PE TEAGUE, PE, PLLC
2705 Waterloo Court, Raleigh, NC 27613
(919)247-2572, peteague50@gmail.com

RE: Engineering - Plan Review and Structural Recommendations
MIKE SAYRE PLAN
Project No.: 23PT-0620A

Thank you for using PE Teague. The plans named Mike Sayre, dated Preliminary 3-30-23, Final 4-17-23 and Revision 5-26-23 by Advanced House Plans and the Roof truss layouts prepared by Longleaf Truss Co. Project SAYRE ; order # P23-05036 with truss data dated Jun 15 2023 were provided by Mr Sayre. The wind speed for the plans was for 115 MPH and the North Carolina State Residential Building Code (NCSRBC) requires 130 MPR. The walls were analyzed for 130 MPH wind loading and will require the following:

FOUNDATION PLAN
SCALE: 1/4" = 1'-0"

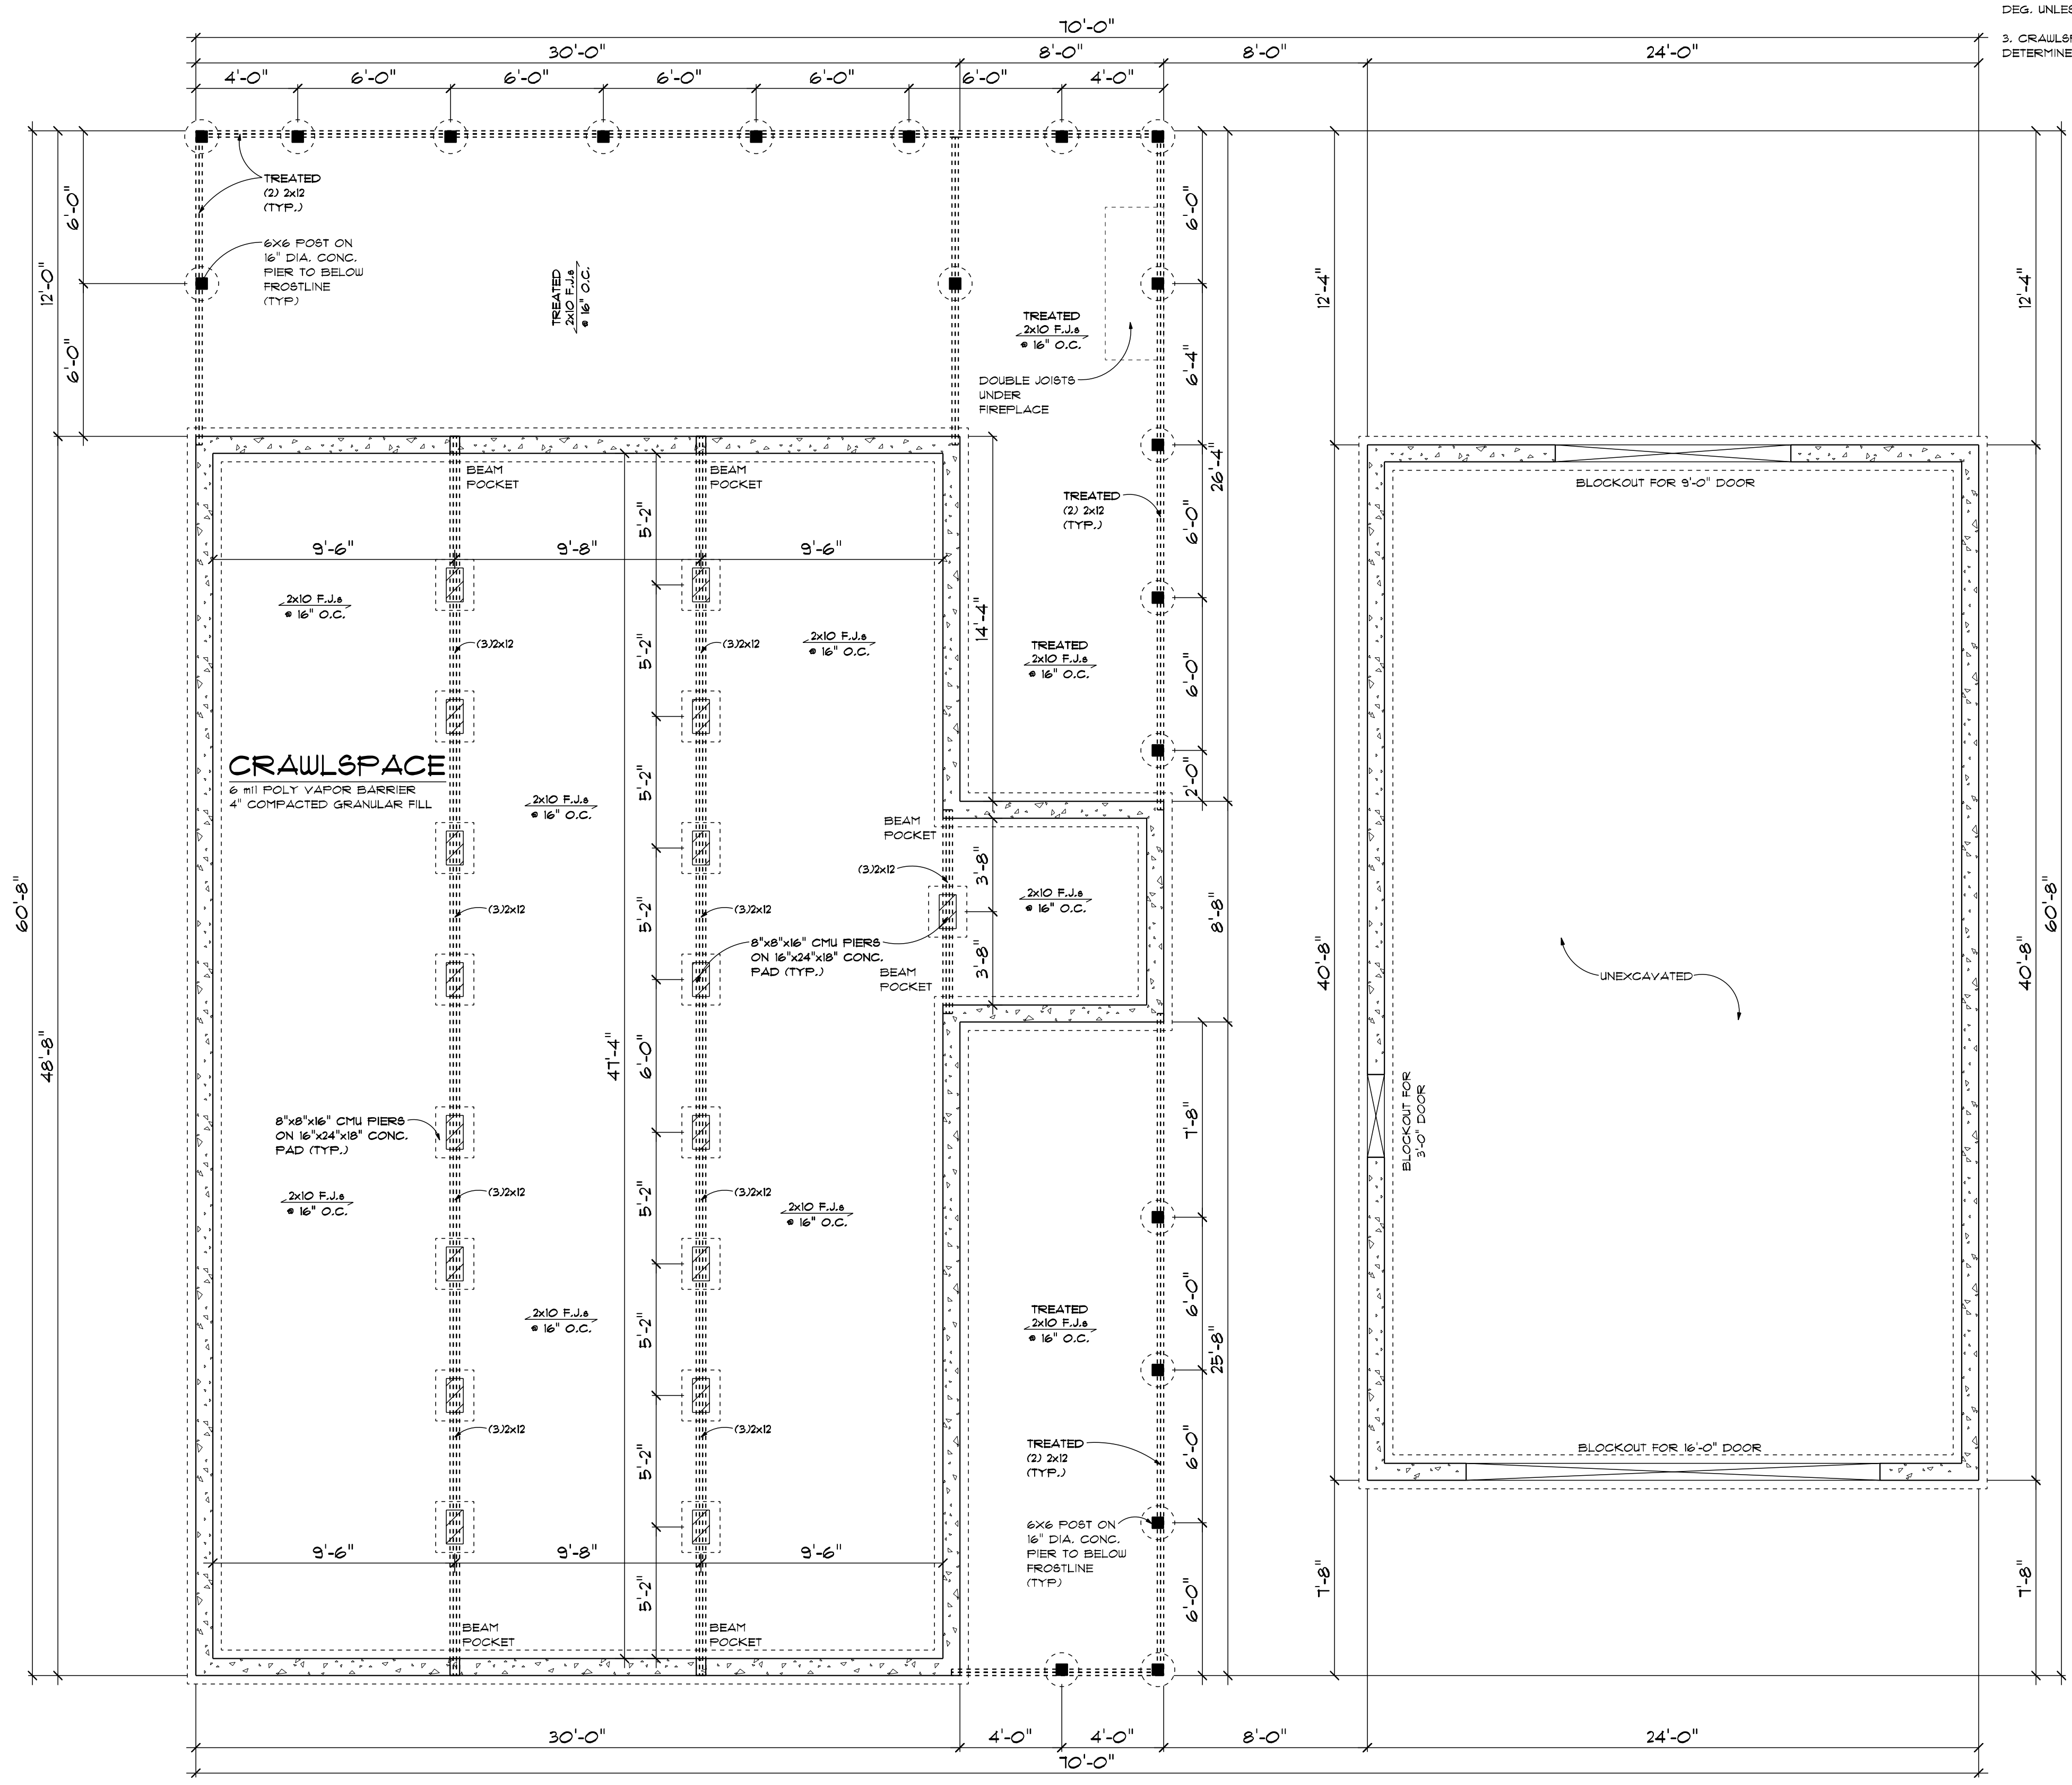
Brace walls for continuously structurally sheathed conditions are adequate with the following exceptions. The front garage wall and the rear wall for the main structure as shown on sheets 2 and 3 of 8 29955. These walls require portal framing in accordance with R602 of the NCSRBC. The headers across the walls should be (2)1.75X11-7/8 LVL's running across the entire walls in accordance with R602 of the NCSRBC. The walls will be required to have a Simpson H2.5 attached to the roof trusses to the top plate for the main structure as well as the rafters (use of conventional framing for the garage - changed from the roof trusses). The porch framing on the exterior require the beams to be treated SYP (4)2X12's spanning no greater than 7ft 2in in the clear and should be posted to a treated SYP 6X6 to be attached to the beams by a Simpson EPC6Z post cap and to the concrete footing by a Simpson ABA66Z post base. The posts should run from the bottom of the beam to the footing. This may require the floor bands to be through bolted to the posts with two 5/8" diameter bolts. The porch post footings will require a 18"x18"x18" concrete for each post. The foundation walls should have 8 inch CMU foundation walls on a 10" thick by 18" wide concrete footing with two # 4 reinforcing steel bars continuously. The walls should have 5/8" diameter foundation bolts 1 ft from each corner and every 6 ft c/c with the exception of the two portal frame walls outlined previously. The exterior porch bands and floor joists appear to be adequate for treated SYP framing members as shown on the plans as shown on sheets 4 and 5 of 8 22915.

CROSS SECTION

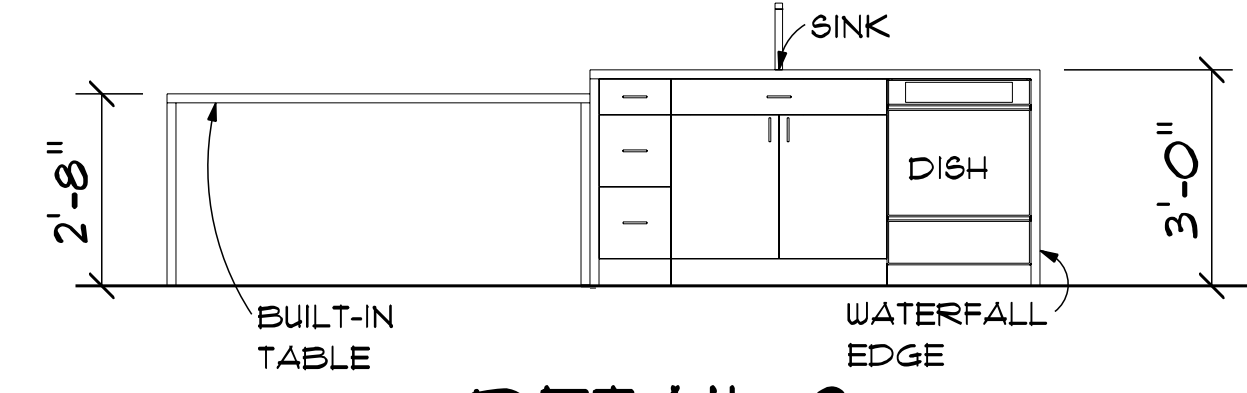
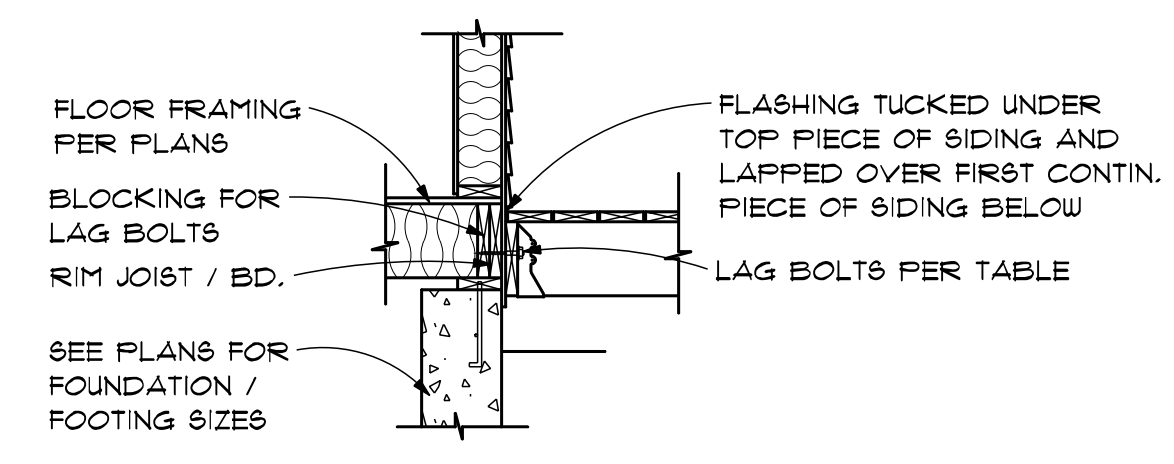
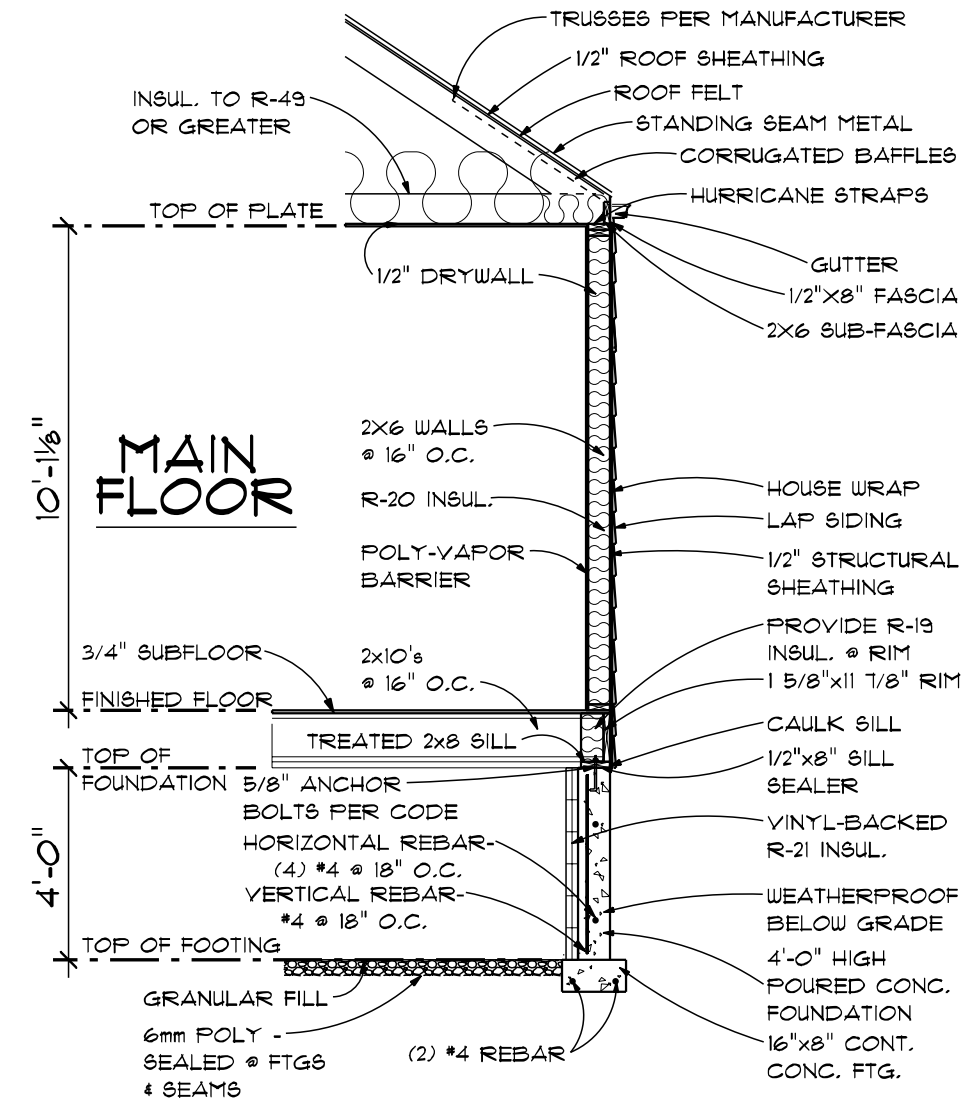
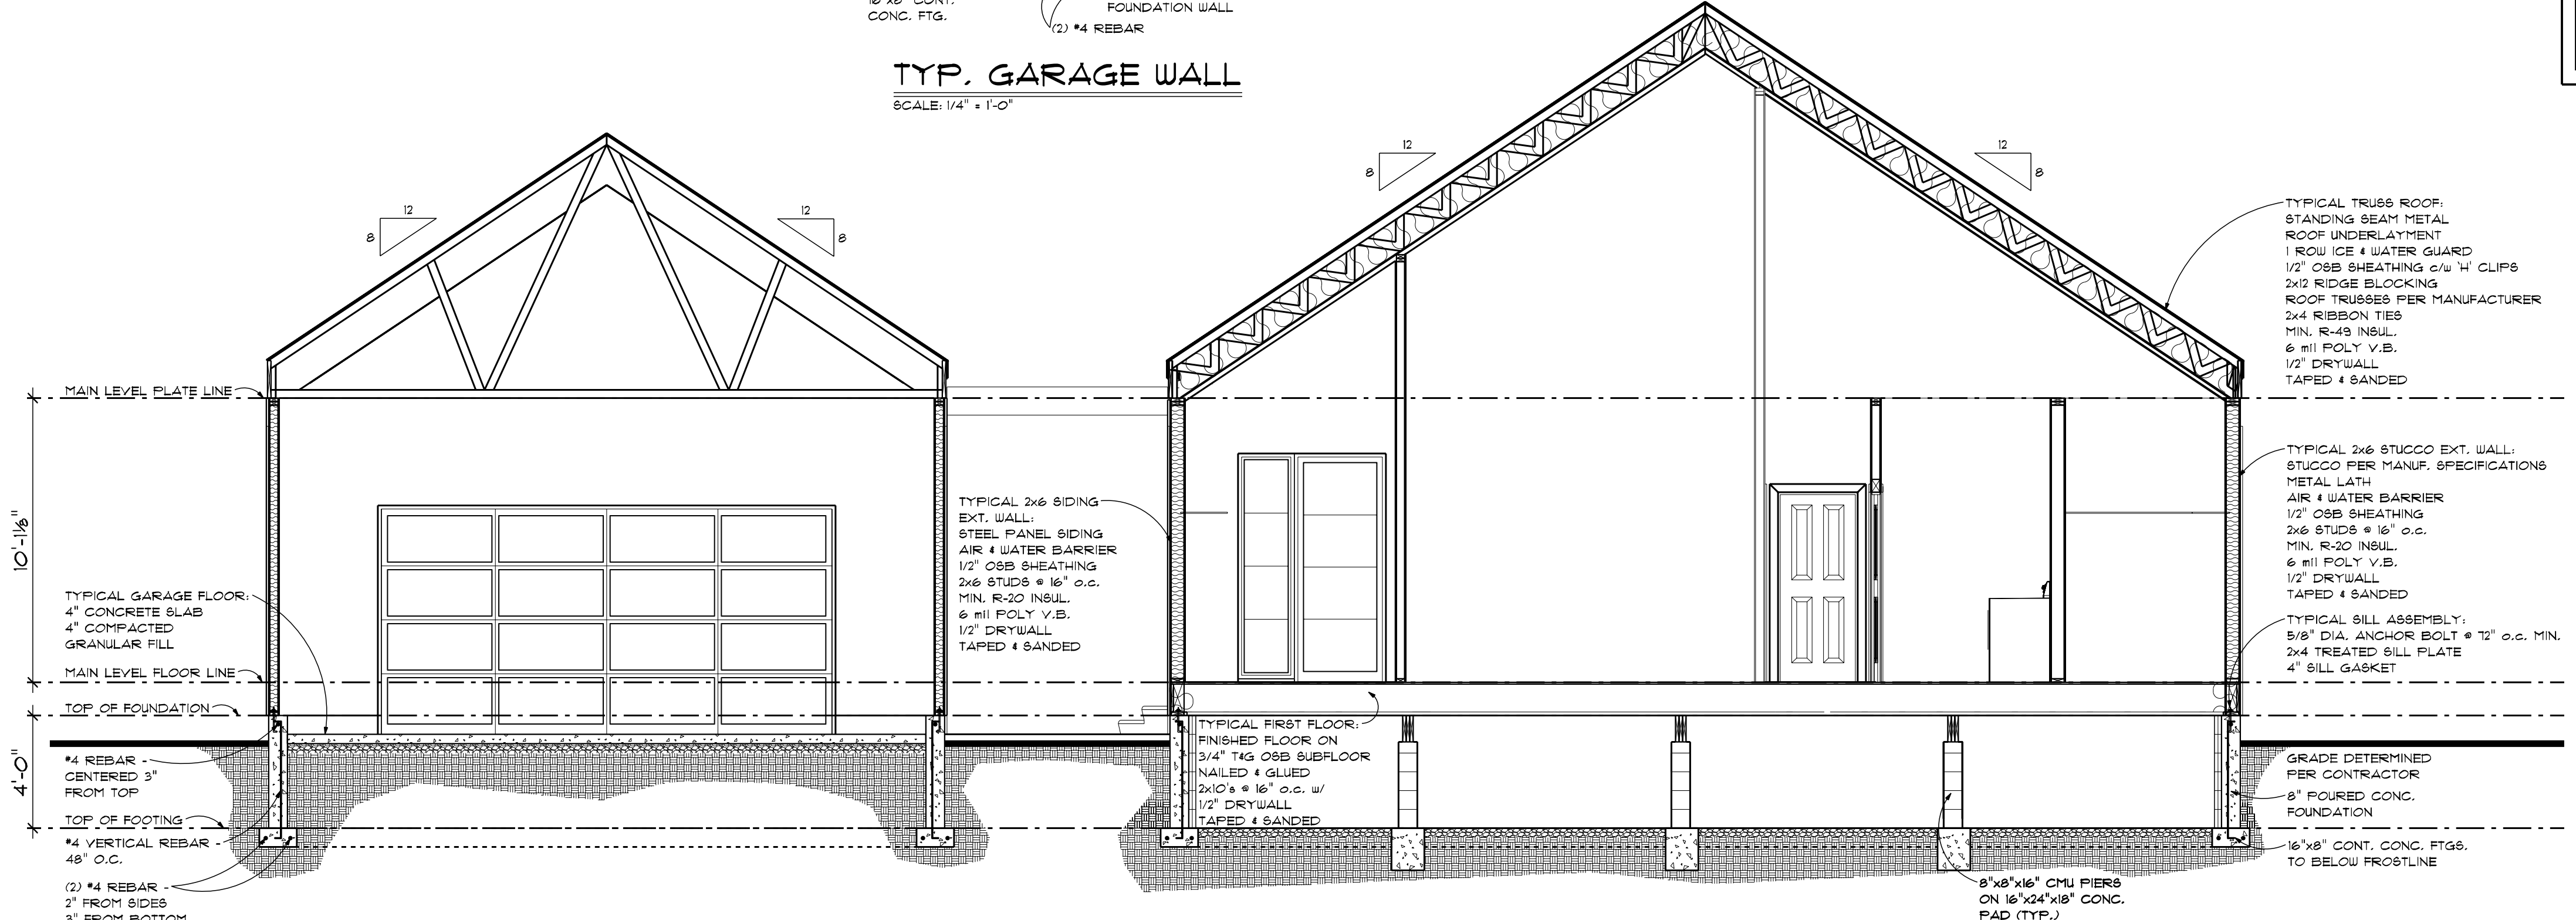
The garage roof and ceiling joists are planned on being conventionally framed by using 2x8 rafters at 16" c/c with a 2X6 collar tie every rafter at 1/3 the ridge height and a 2X10 ridge board. The ceiling joist will require an I-joist every 16" c/c. The I joist spanning 24 feet left to right (BCI 60s 2.0 or equivalent) would need to be a 11-7/8 inch deep joist for ceiling load only or a 14 inch deep joist for floor (40 PSF LL).
